CITY OF PORTLAND BUILDING PERMIT

Job ID: 2012-02-3351-ALTCOMM

Kitchen Exhaust System Checklist and code Provisions

Jeanie Bourke - Re: Vignola hood, 10 Dana, 032-V-001

1st FLOOR PLAN VIEW

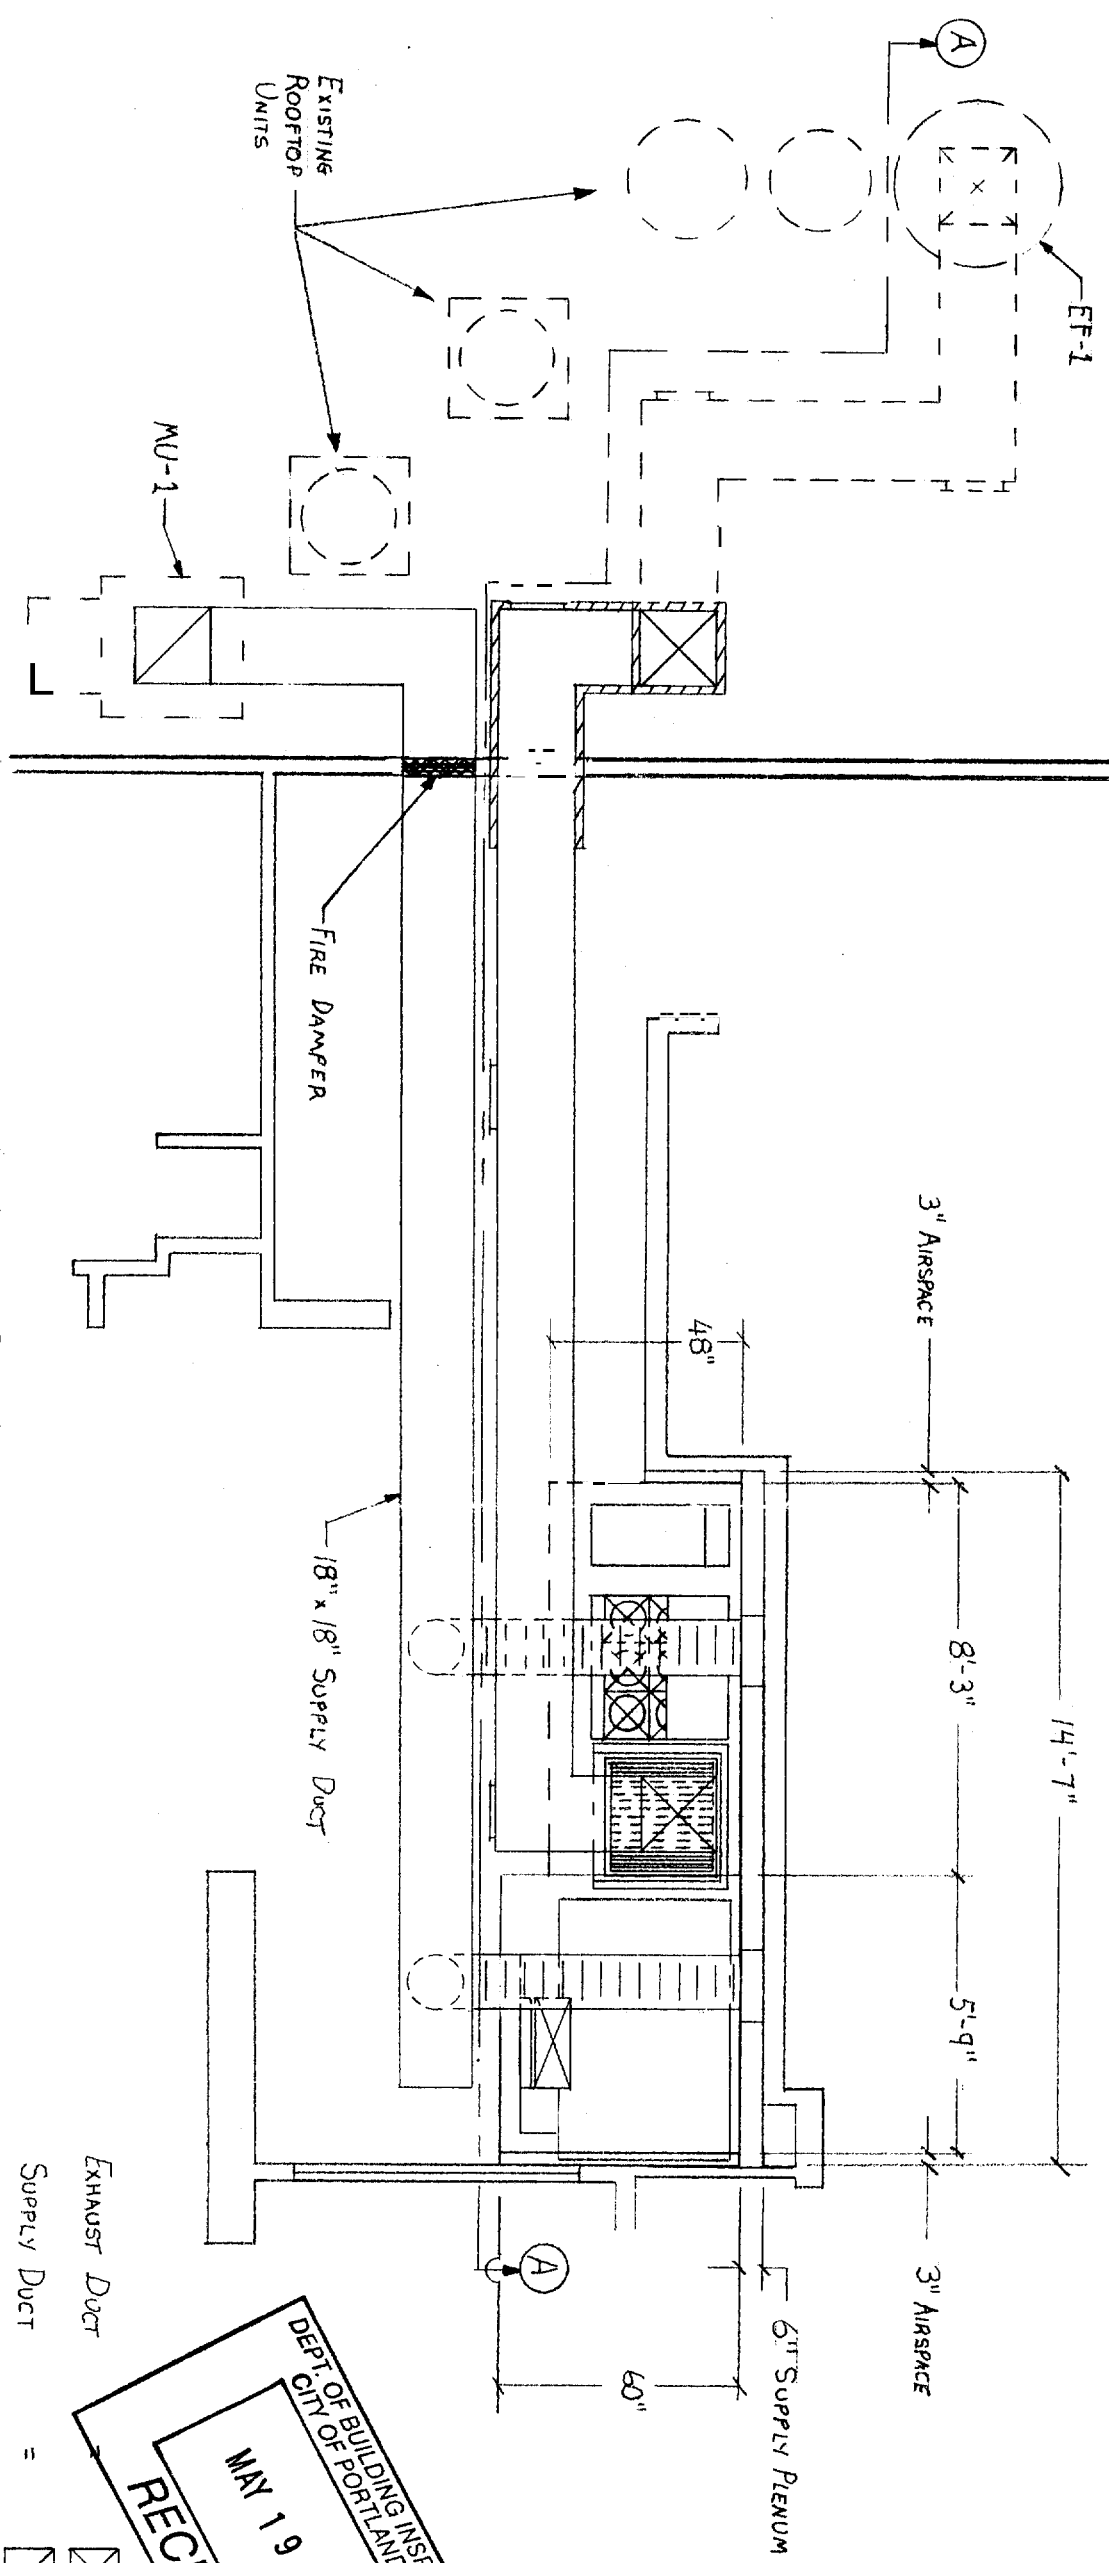
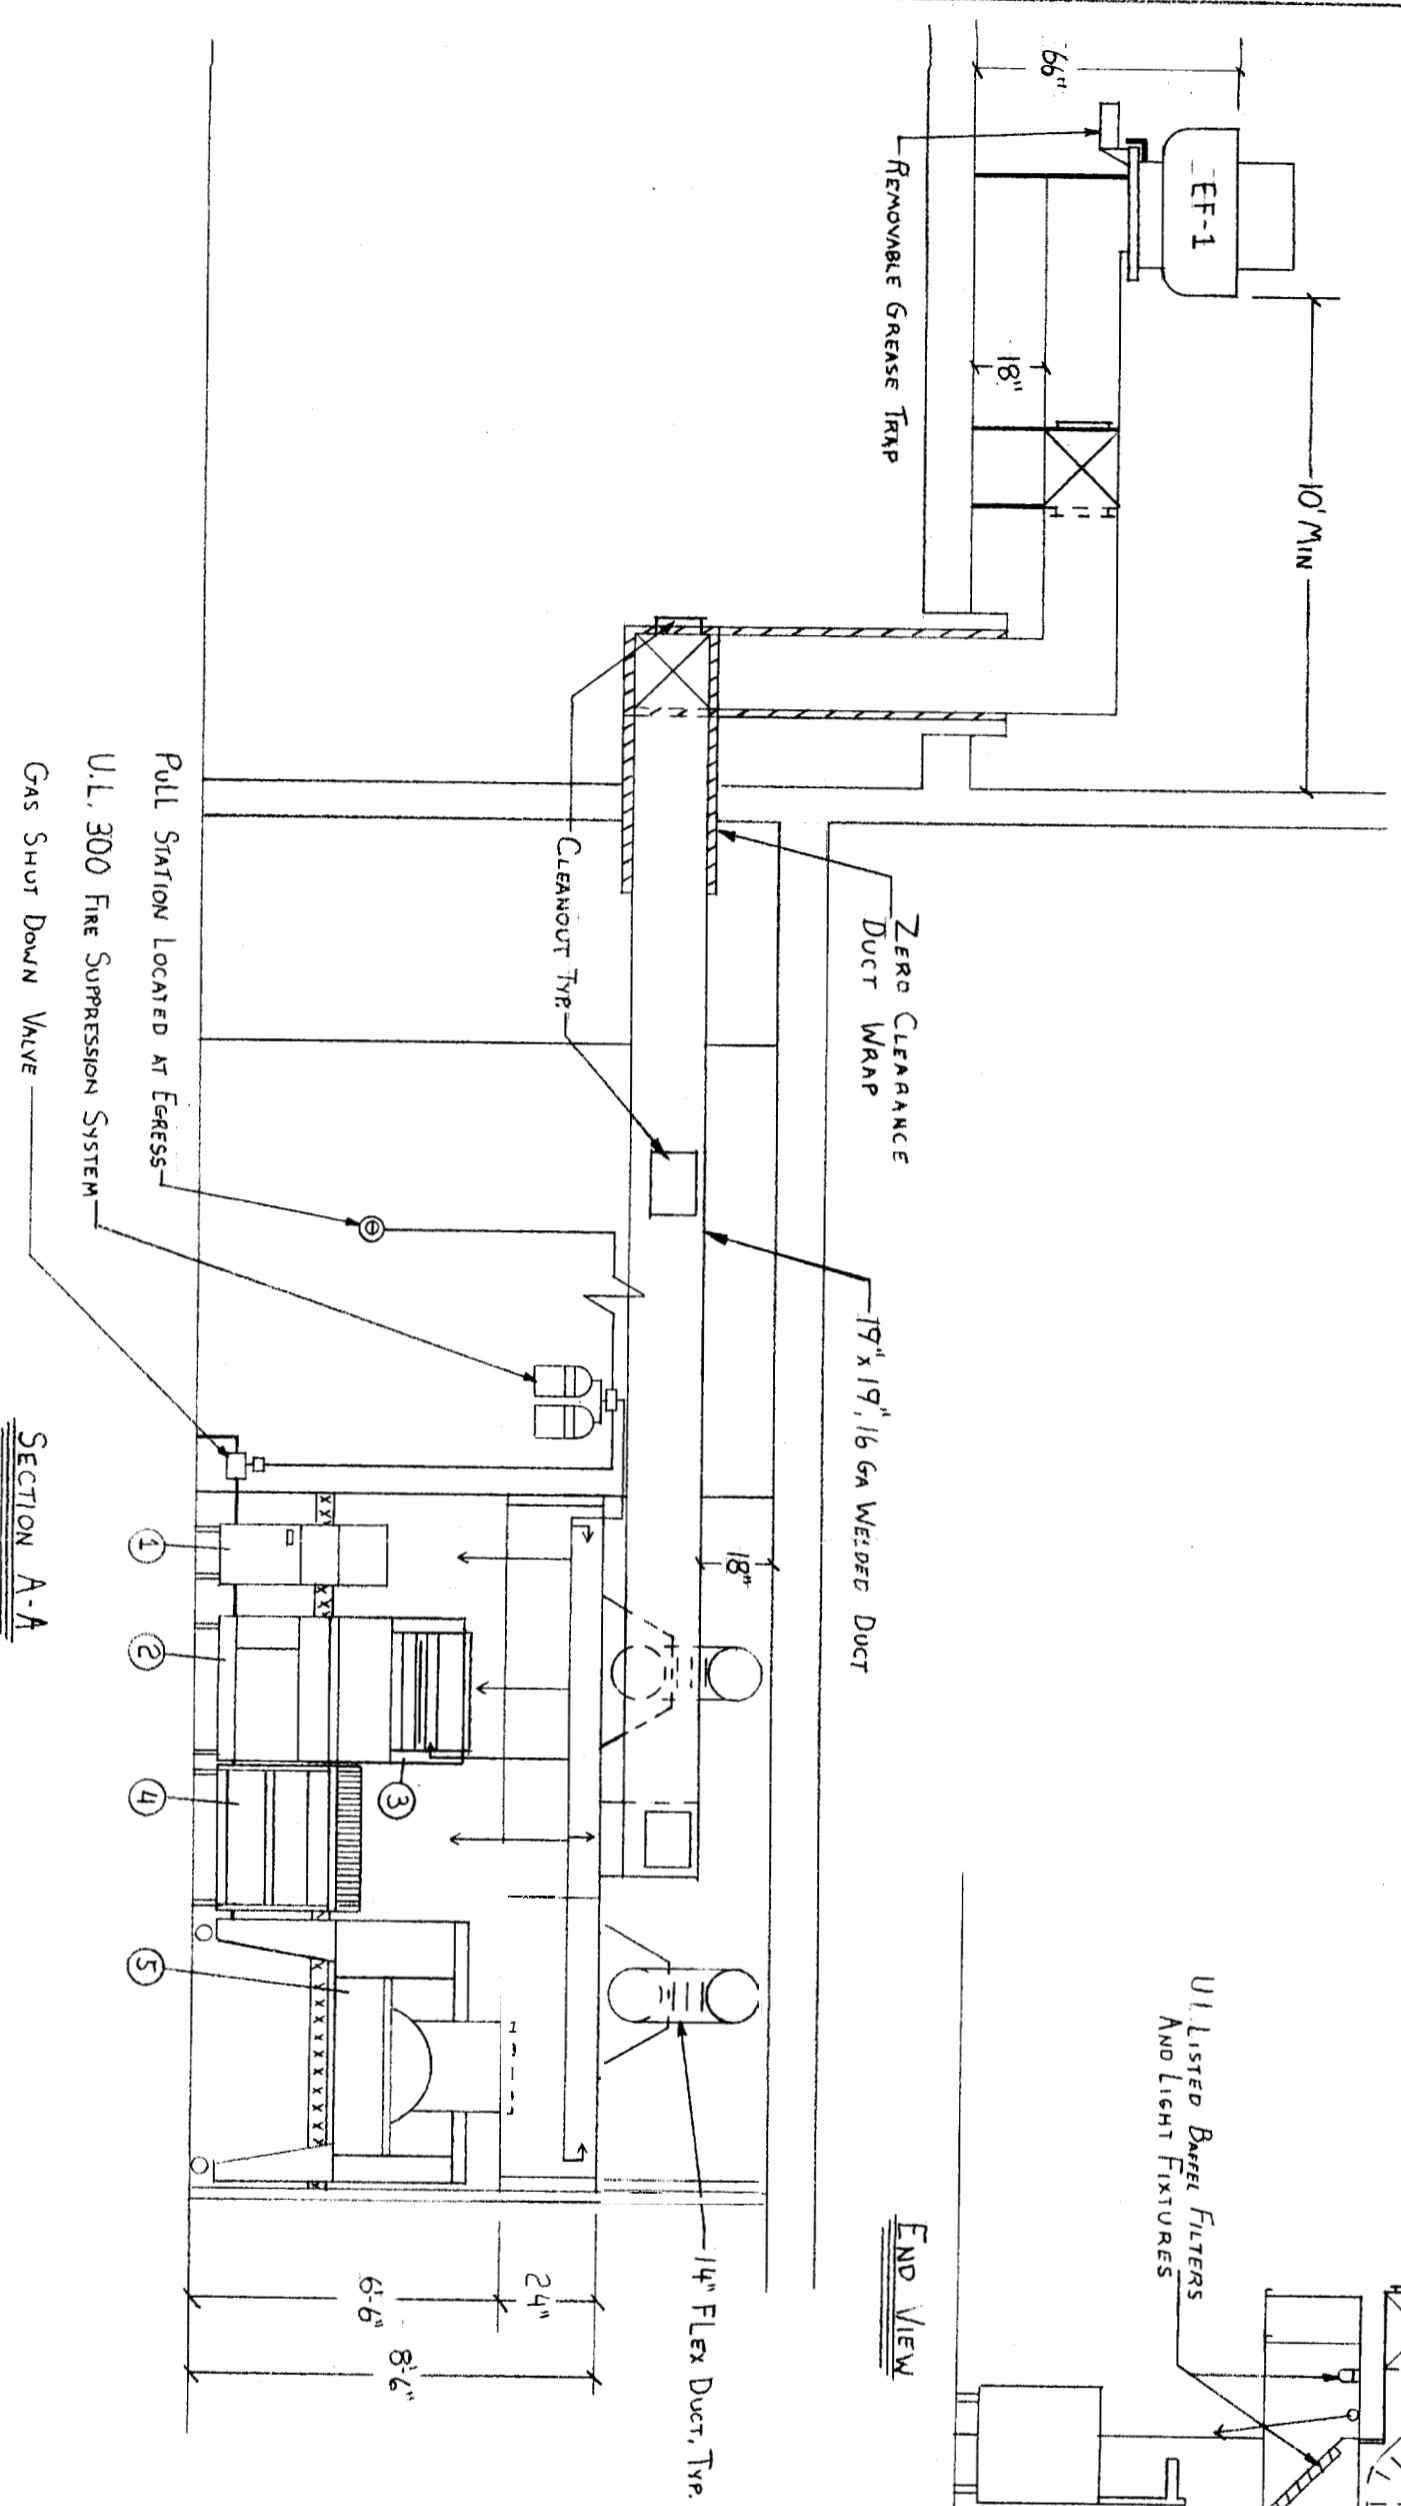
After reviewing NFPA 96 and conferring with the fire Lt. Ben Wallace, we agree that the wood framed wall with 2 layers of fire code gyp does not constitute a limited combustible (Sec. 3.3.35.2) wall and will need clearance reductions as specified in Sec. 4.2.1 & 4.2.3. The structural base or framing cannot be combustible if utilizing the reduction methods.

Please provide a detail showing how this will be compliant.

Also, I forgot to ask you when we spoke this morning about the clearances of the hood to combustible construction. You mention this on the application, however, if the walls are combustible framing, will you be using one of the reduction methods, and if so, please provide this design detail.

As discussed at the stairwell wall we will be adding 1" spacers on the 2 layers of 5/8" with 1" mineral wool and 24 ga stainless steel. At the small wing wall we will have 1 layer of 5/8" and the same spacing detail.

Hello Jeanie,
As per your conversation with Aaron, we will use the reduction method described in section 4.2.3.2 to reduce the clearance to combustibles to 3". Aaron said that you agreed to leaving the existing hood as is.
